From: Anita Gardner <Anita.Gardner@arun.gov.uk>
Sent: 17 August 2021 19:32
To: Planning.Responses <Planning.Responses@arun.gov.uk>
Subject: FW: PO/8/21/L Peckhams, Poling Street - Renovation of stable building

From: Anita Gardner
Sent: 17 August 2021 19:32
To: [REDACTED]
Subject: PO/8/21/L Peckhams, Poling Street - Renovation of stable building

The Conservation Officer has provided comments in respect of the above application. Can you please provide confirmation/ additional details in respect of the following:

TITLE
Proposed
Floor Plans &
Elevations
Site Plan

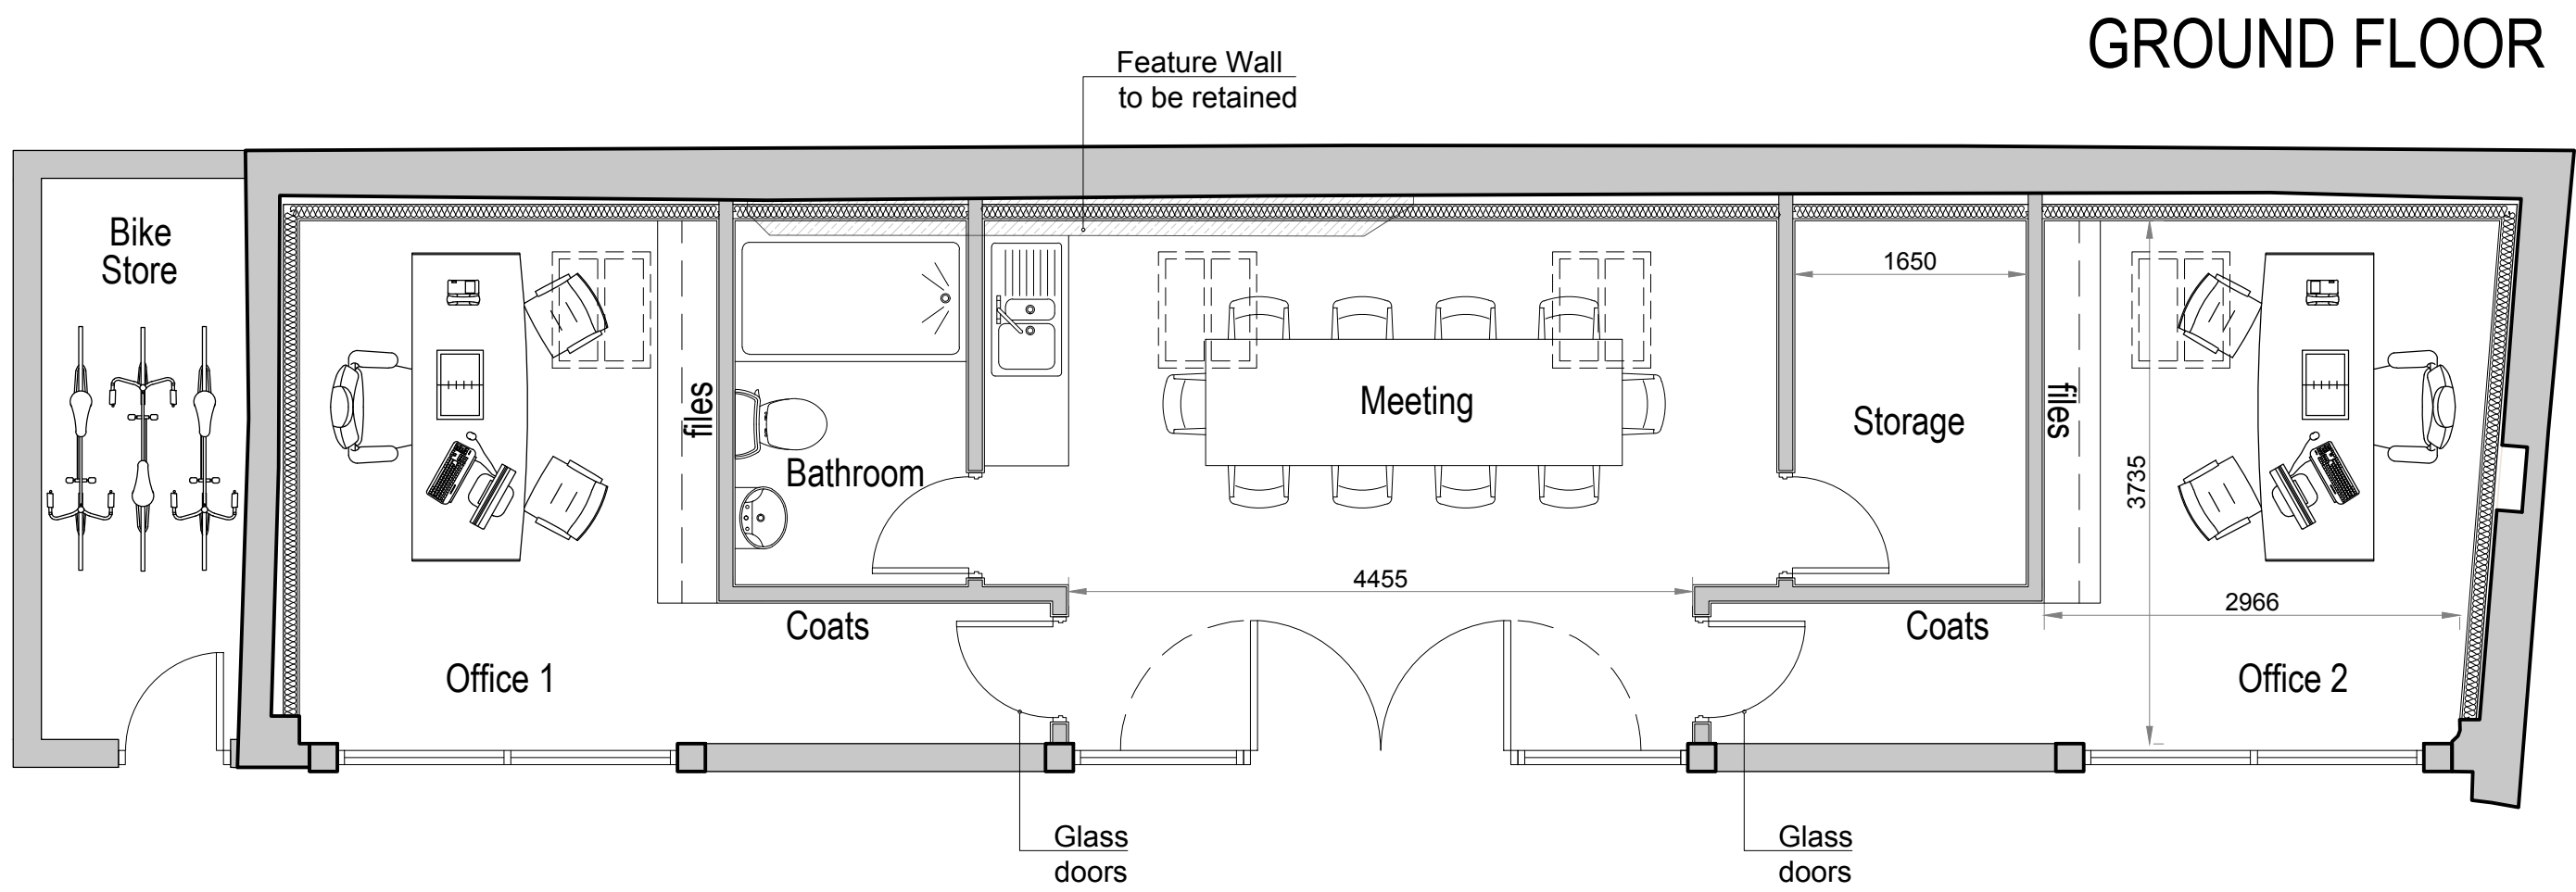
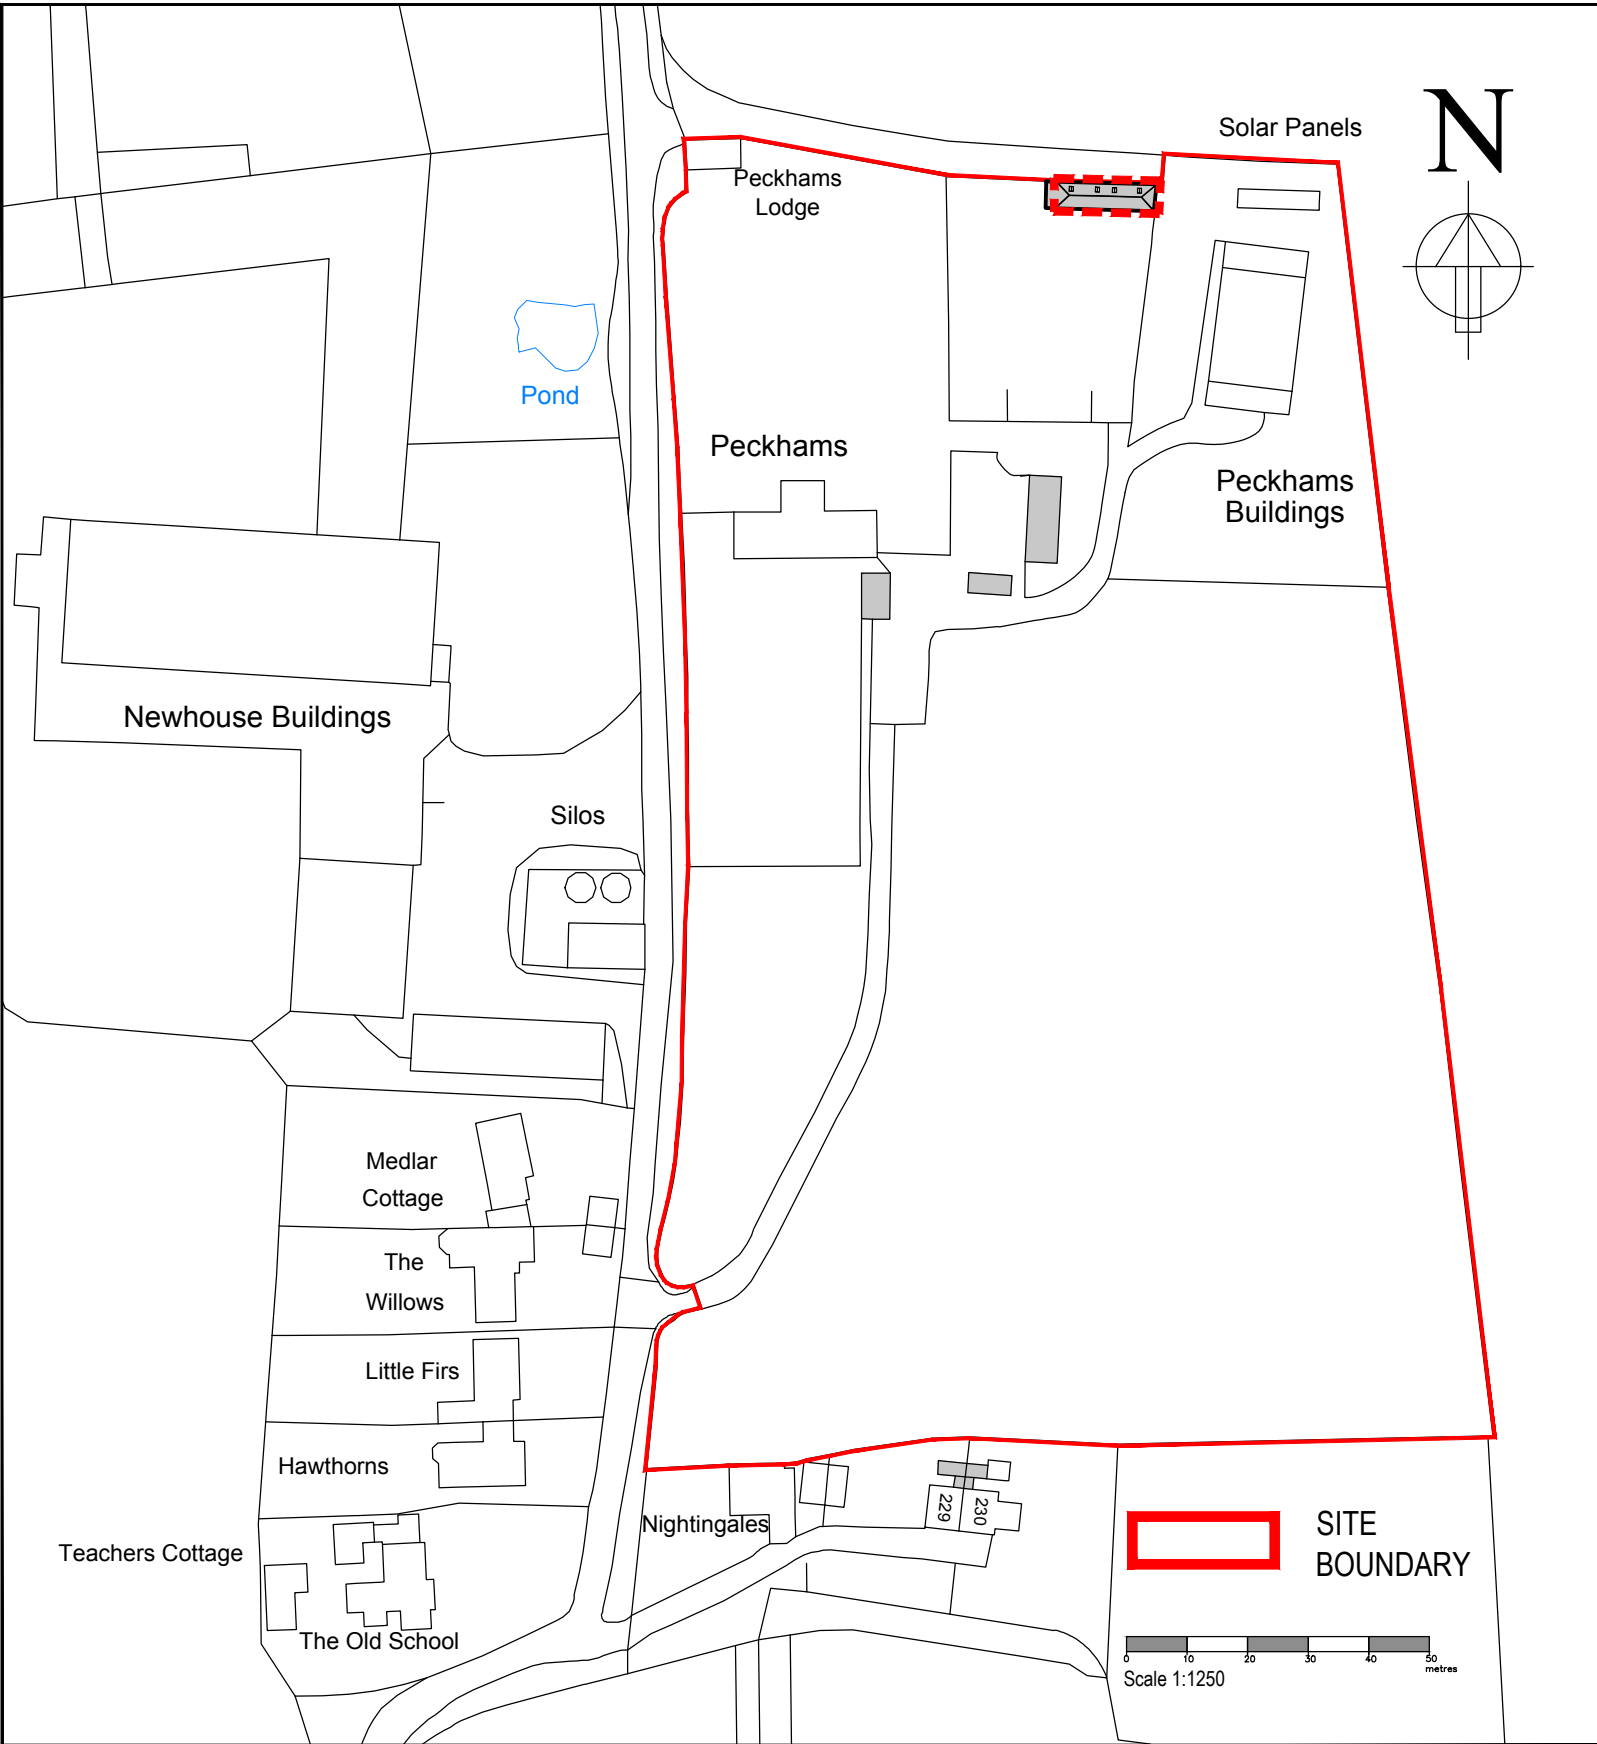
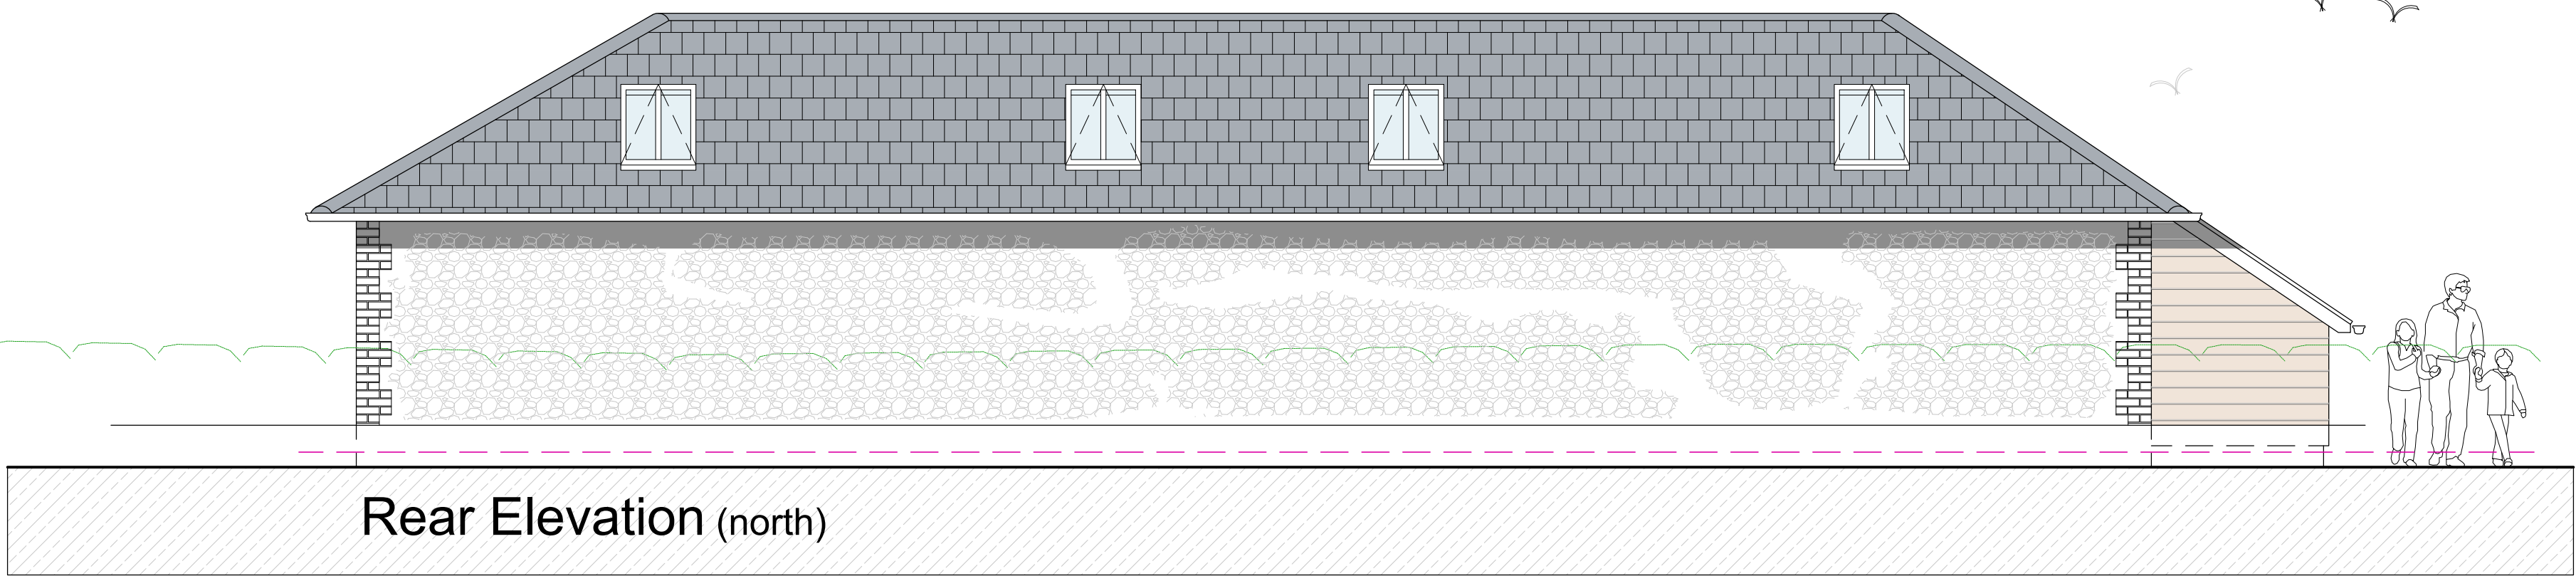
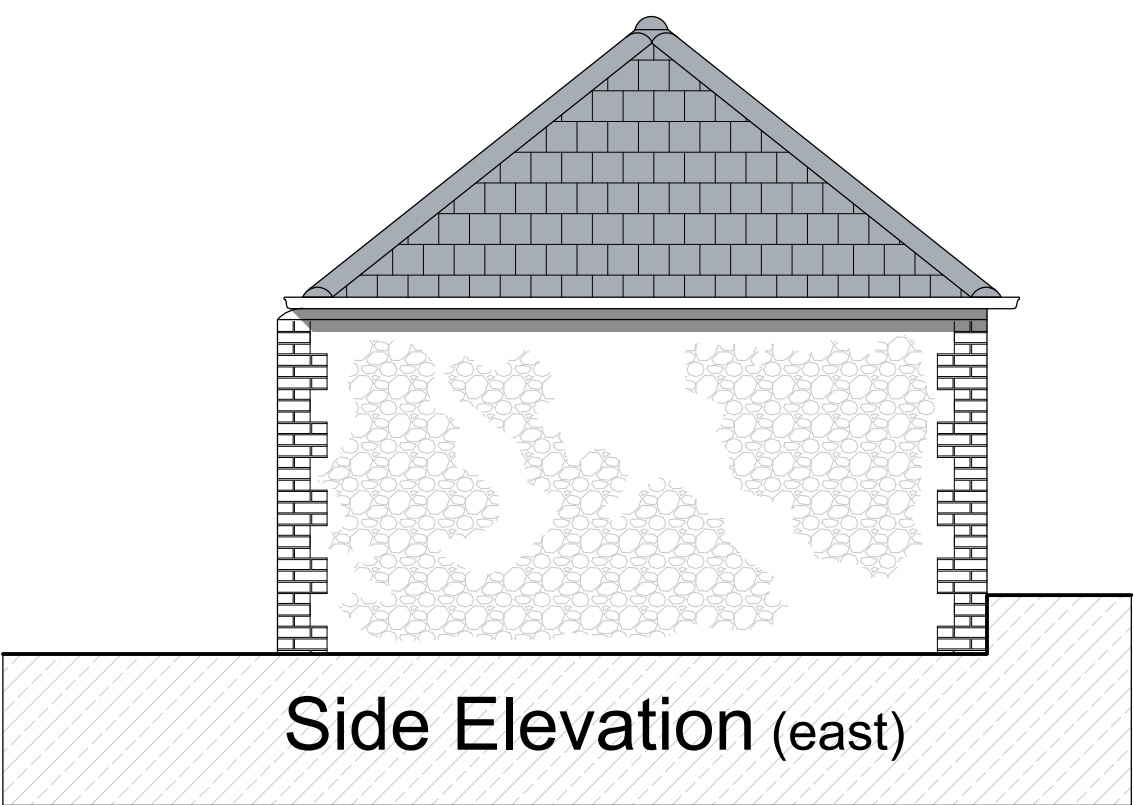
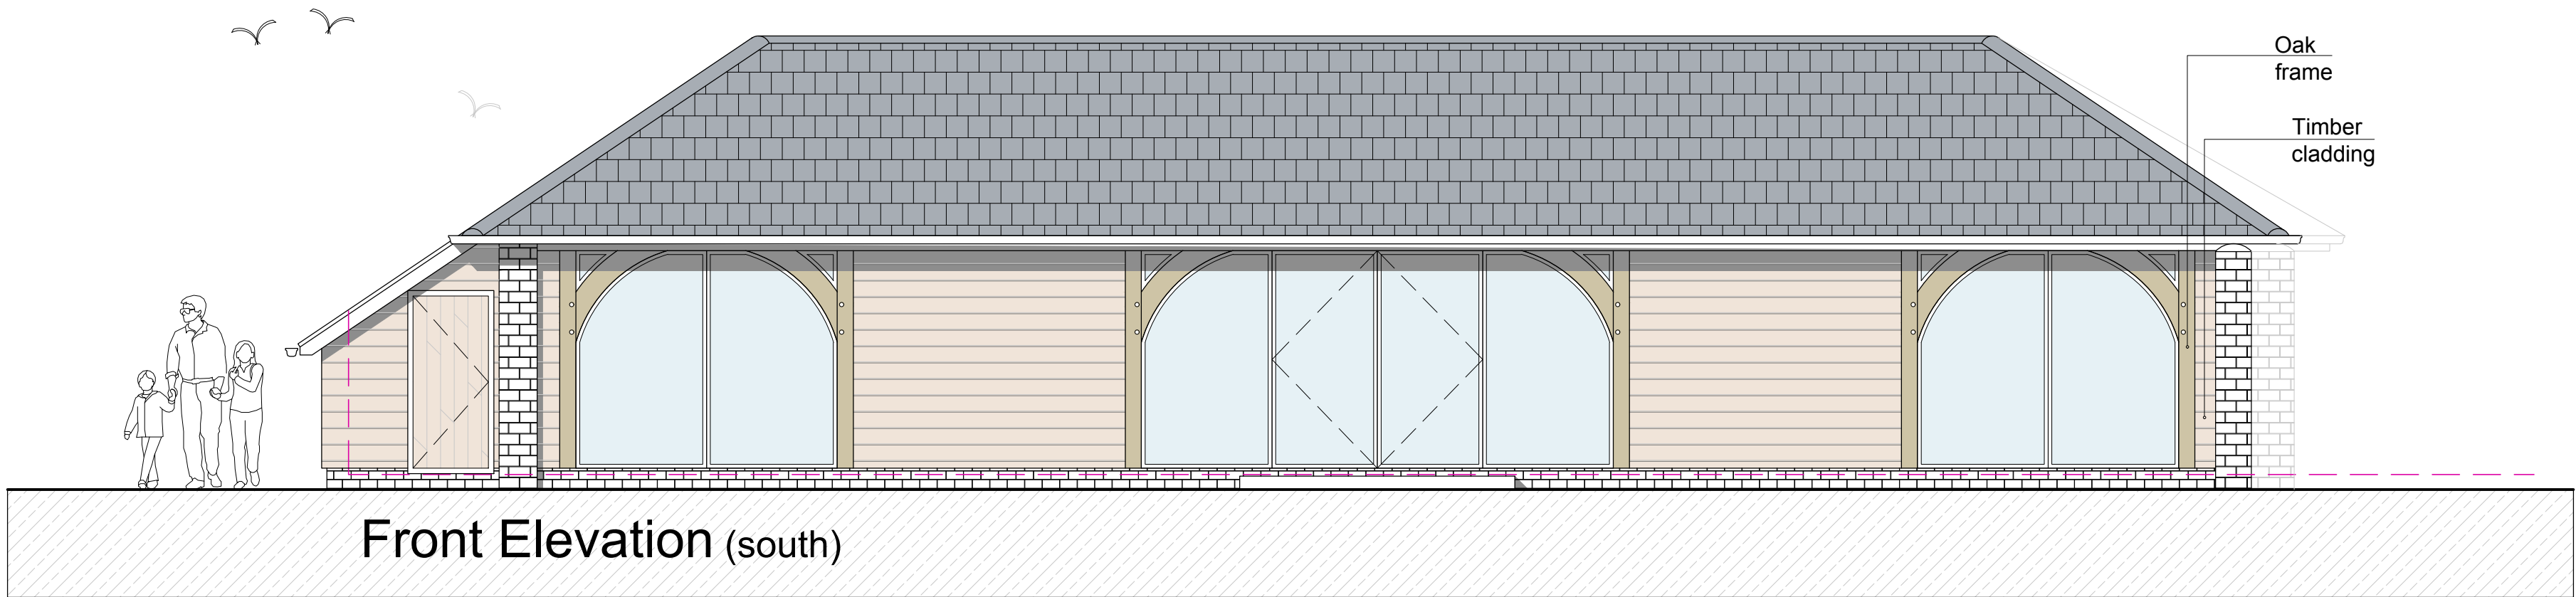
- The statements associated with the application identifies that the timber frame to the front elevation is to be retained on show by the installation of timber panels or glazing between the framework rather than being covered up as currently exists. However, this is not clear if the existing ones will be relocated in order to accommodate the large central glazed area, nor if the existing staddle stones will be re-used.

- It would help to understand if the rooms are to be left open to the roof void. Such an approach ensures that the character of the existing space can be understood as opposed to the installation of modern ceilings, which is a feature not associated with agricultural buildings such as this. This also needs to be confirmed.
- Careful consideration would also need to be given to any potential landscaping which could be necessary in order to facilitate such a use in respect of the need for any hard standings or pavements and planting. It would help to understand what this will look like.
